Application for Removal or Variation of a Condition following Grant of Planning Permission or
 Listed Building Consent

Two-storey rear extension, front infill extension, fenestration adaptations and internal alterations.

SDNP/23/03649/HOUS

Drawing No.
D6020 - DPA - 004

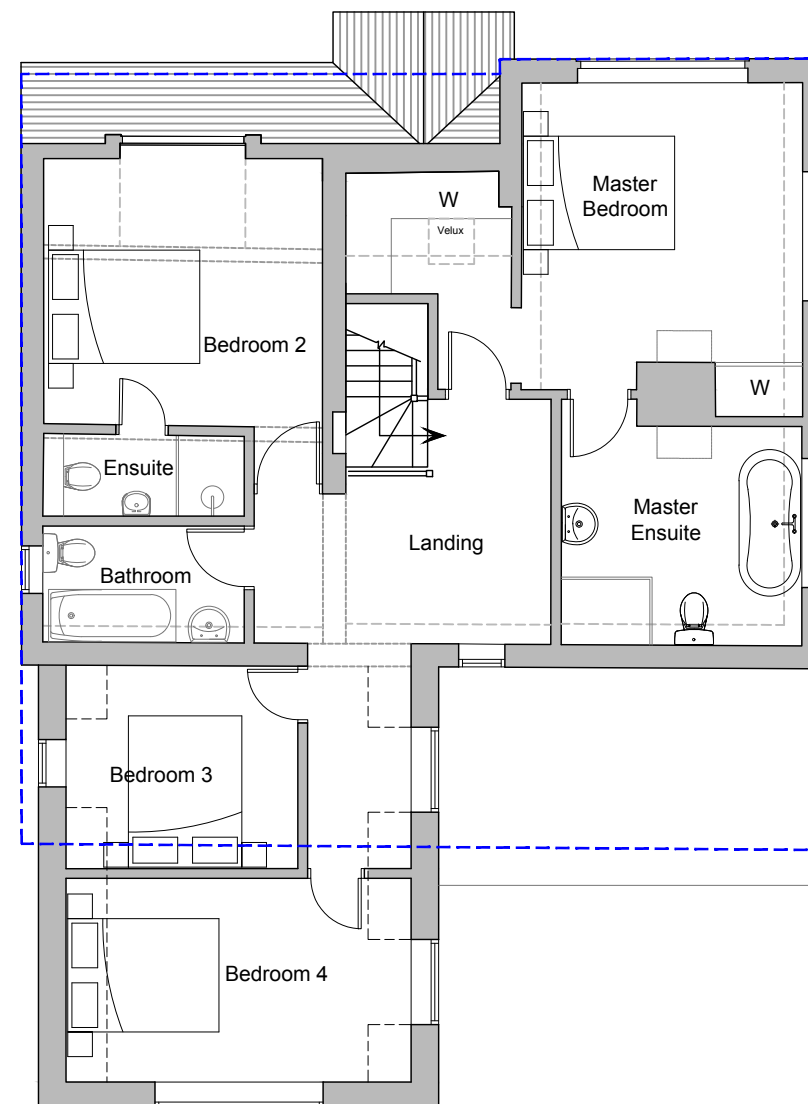
Drawing D6020-DPA-04 to be substituted with drawing D6020-DPA-04-RevB
Drawing D6020-DPA-06 to be substituted with drawing D6015-DPA-06-RevB

D6020 - DPA - 06

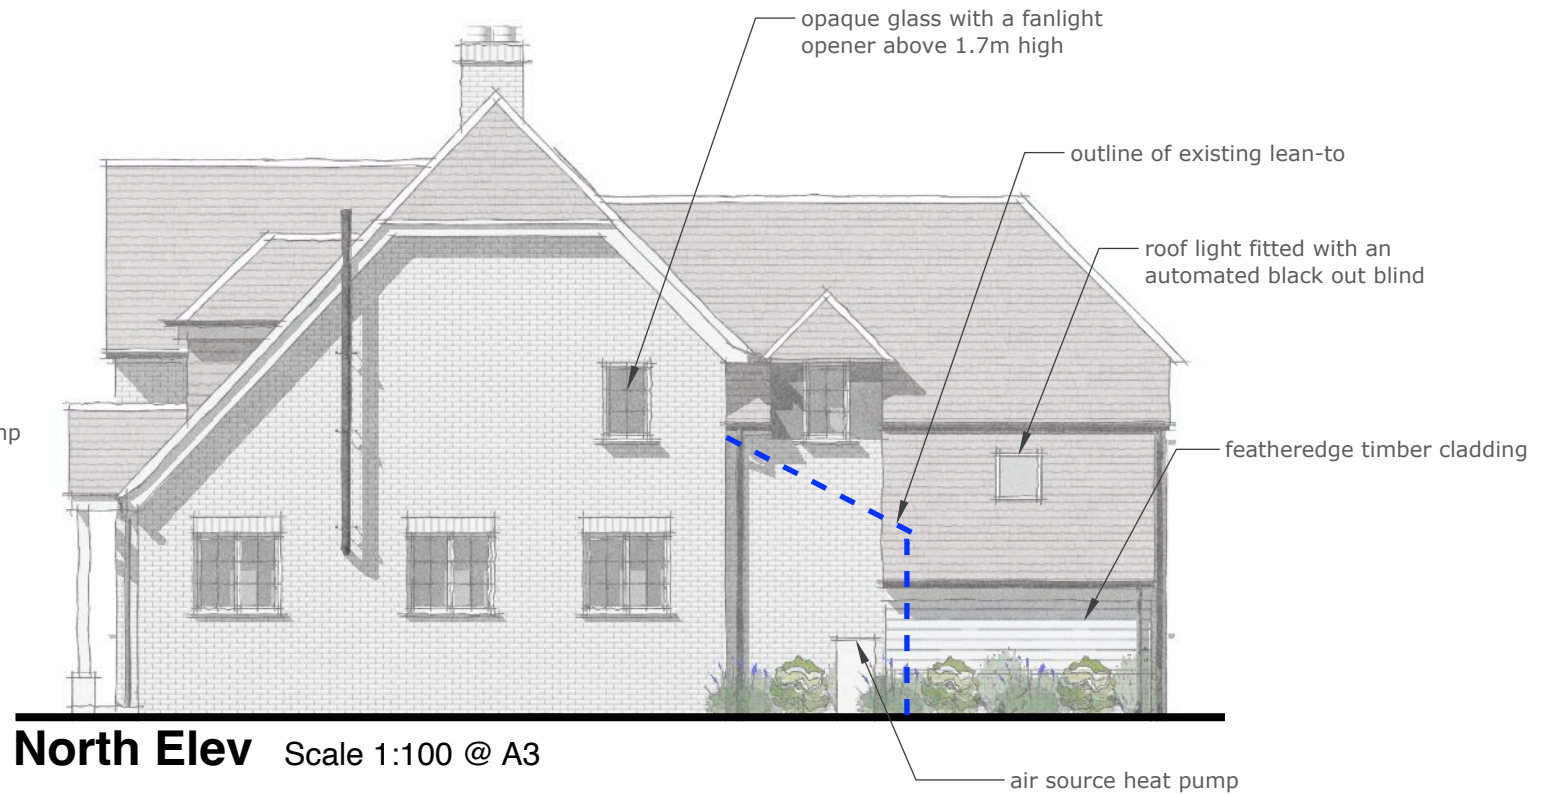
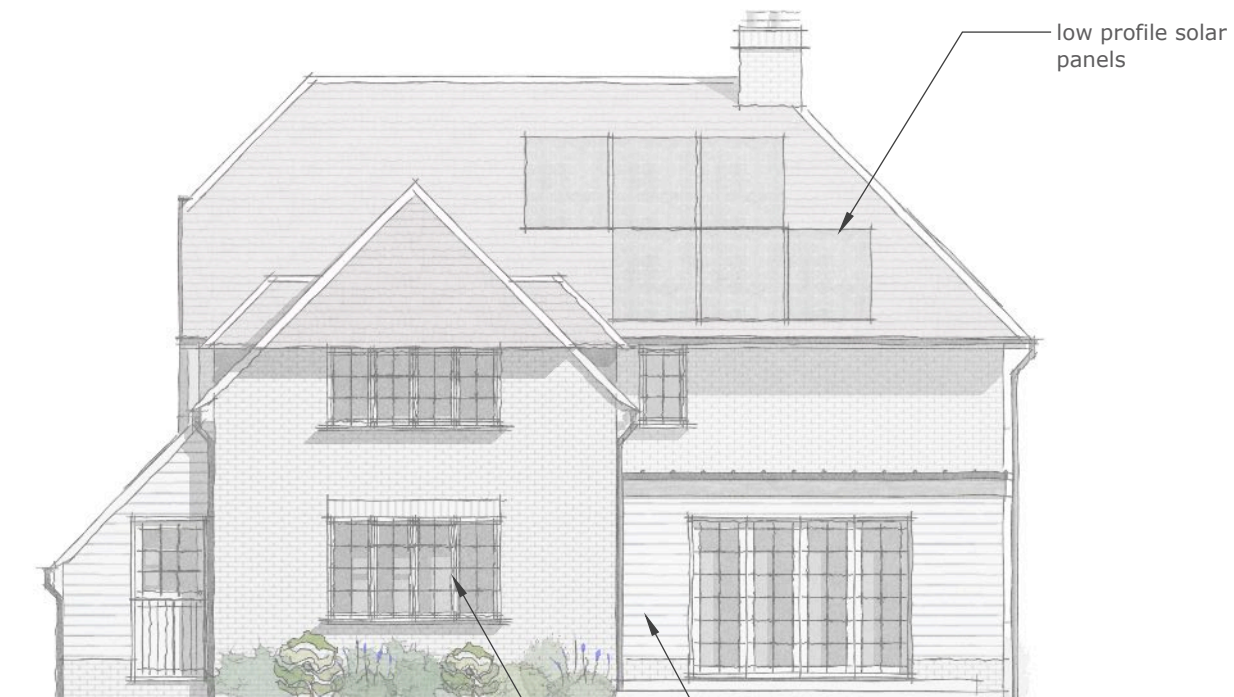
New Roof Light on North Elevation.
Smaller landing window on West Elevation.
Removal of Oak Posts and Braces on single-storey element West Elevation.
Higher brick plinth on timber clad elements.
Lead dormer cheeks instead of timber clad.
Air source heat pump.
Removal of the window in boot room - East Elevation.
Solar Panels on West & South Elevations.
